KITTITAS COUNTY

MEMORANDUM

TO: All Staff
FROM: Public Works Plan Review Team
DATE: October 9th, 2023
SUBJECT: Public Works Comments: VA-23-00007 Chappelle

Drawing name: **PRELIM SITE MAP**

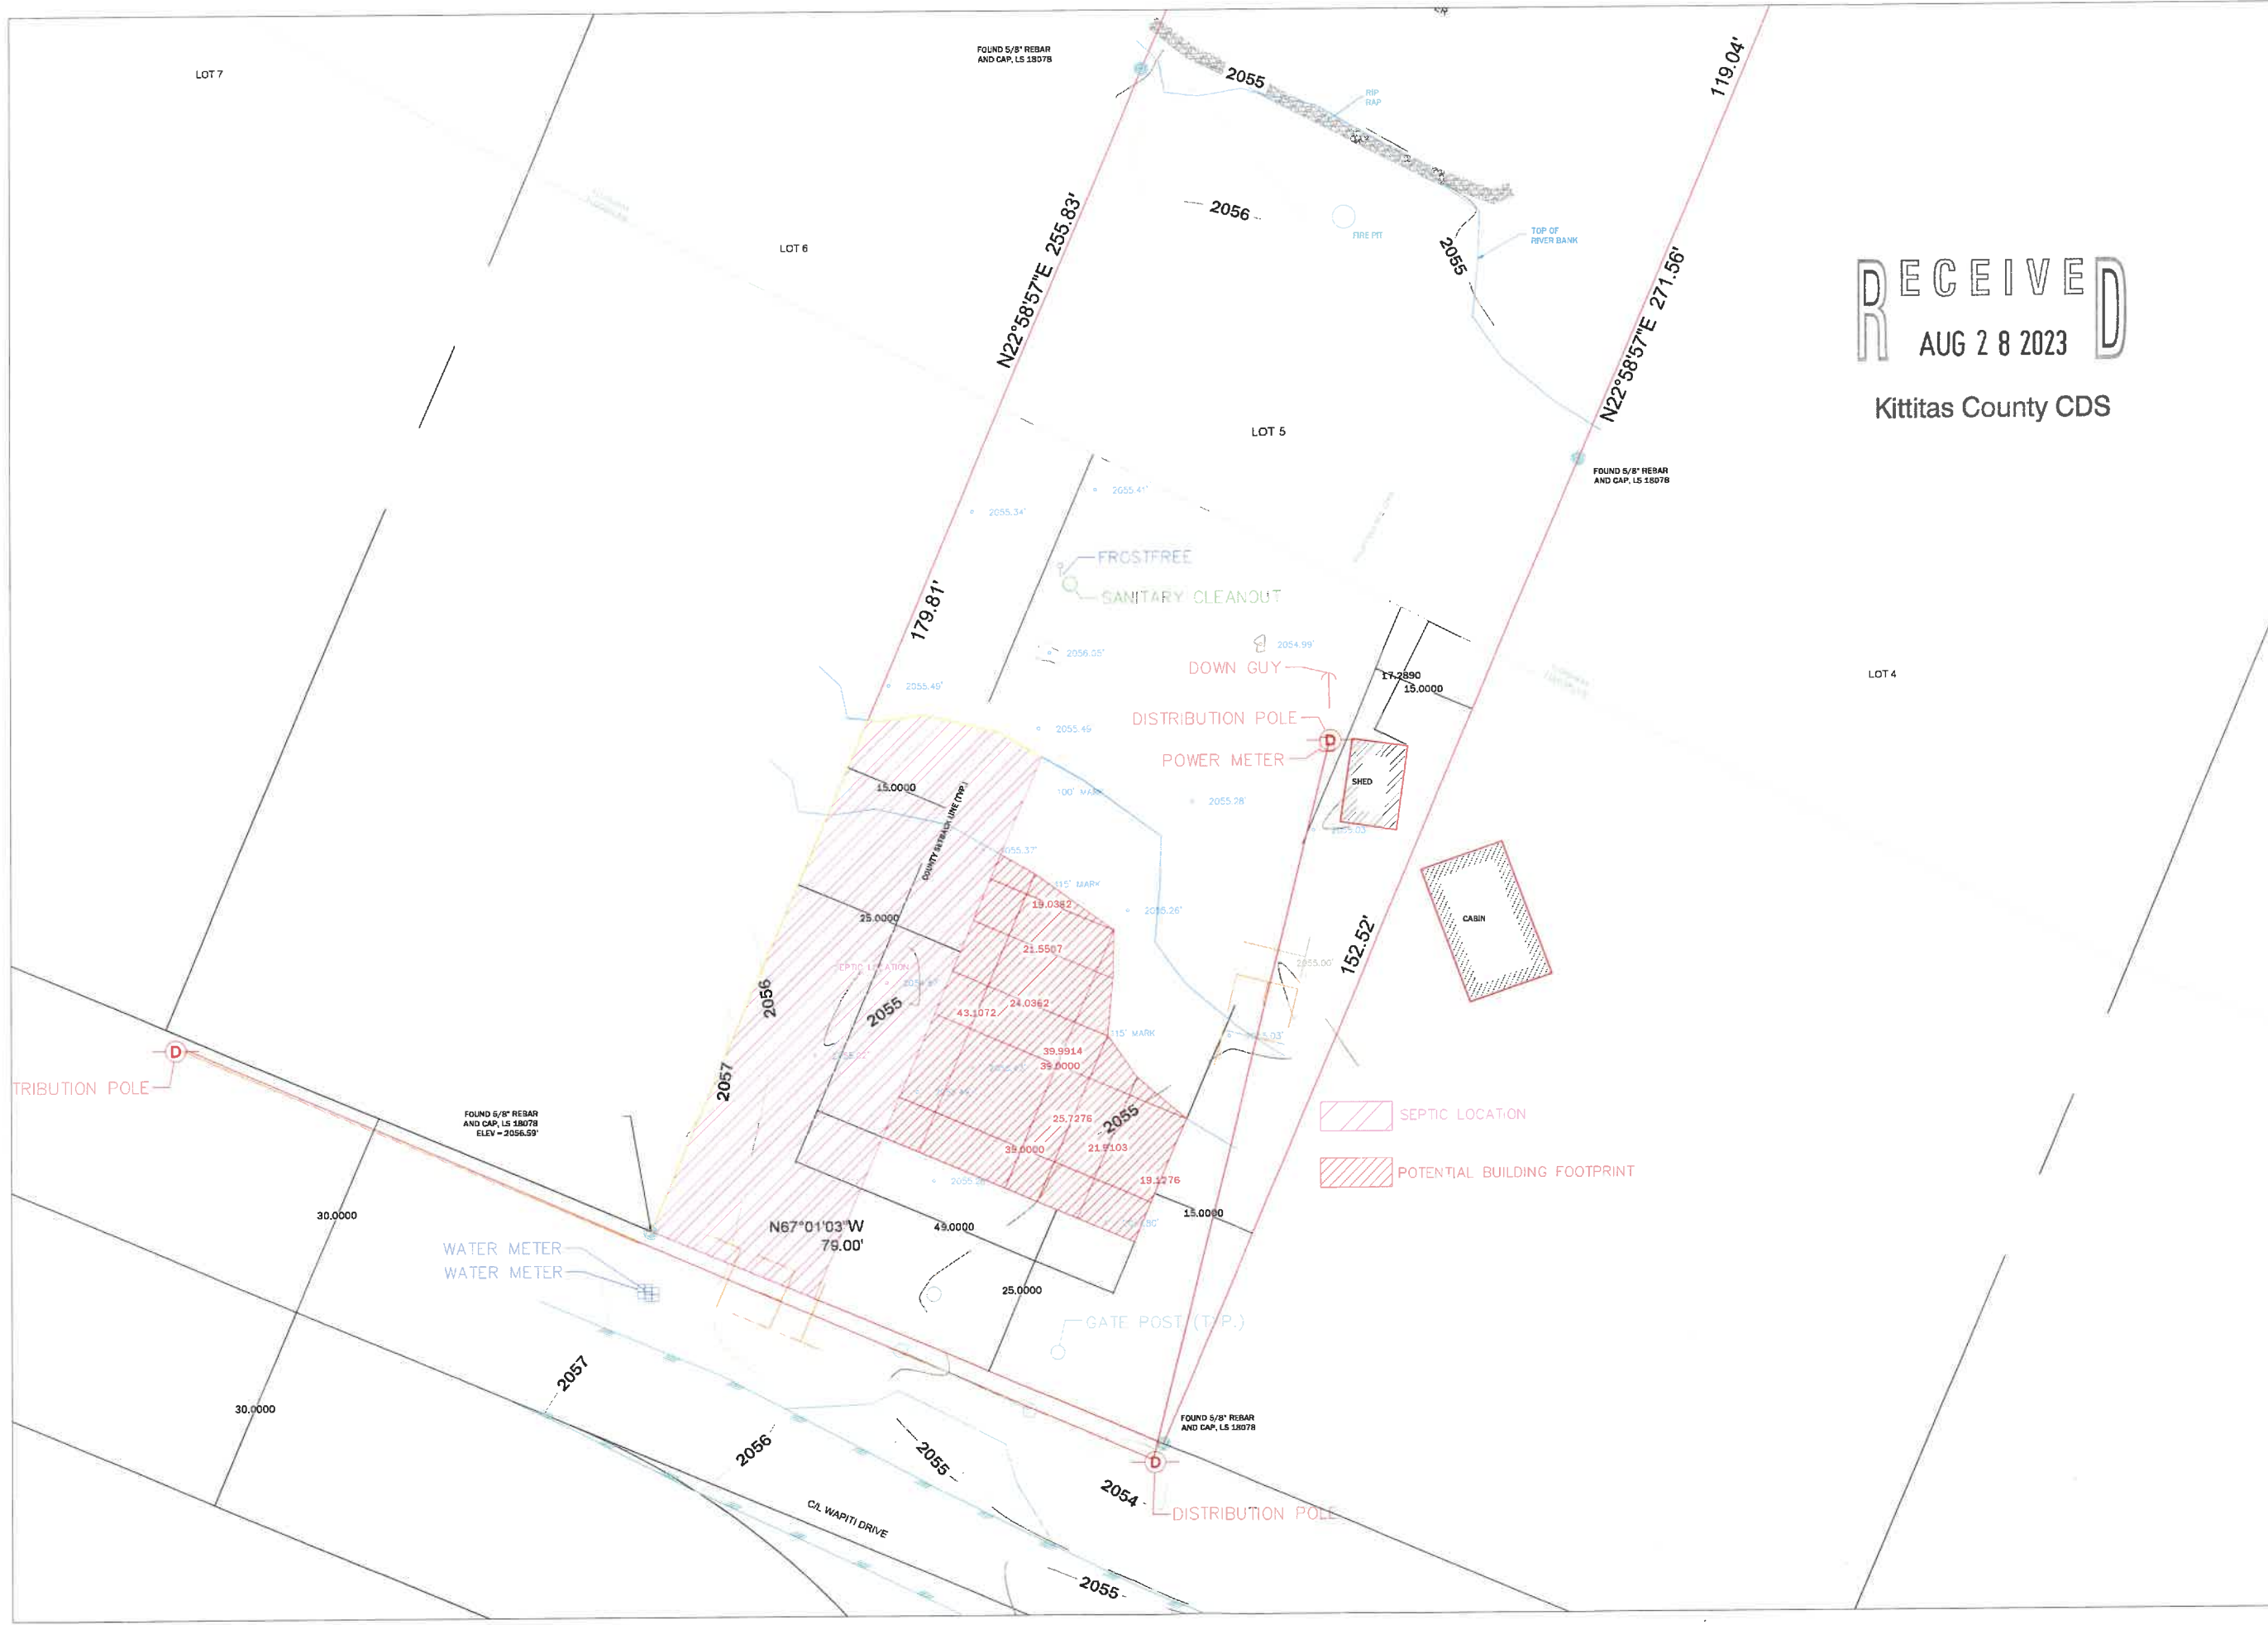
SURVEY	There are no survey comments regarding this application. (JT)
TRANSPORTATION CONCURRENCY	No transportation concurrency application requirement for this project. (KAH)
FLOOD	The proposed variance to the front yard set-back is necessary for the applicant to be in compliance with KCC 14.08.300 and shoreline setbacks by building outside of the floodway boundary and 115 feet from the OHWM. If not completed already, the applicant must utilize a surveyor to identify the floodway boundary. (SC)
WATER MITIGATION/ METERING	No comments. (SC)
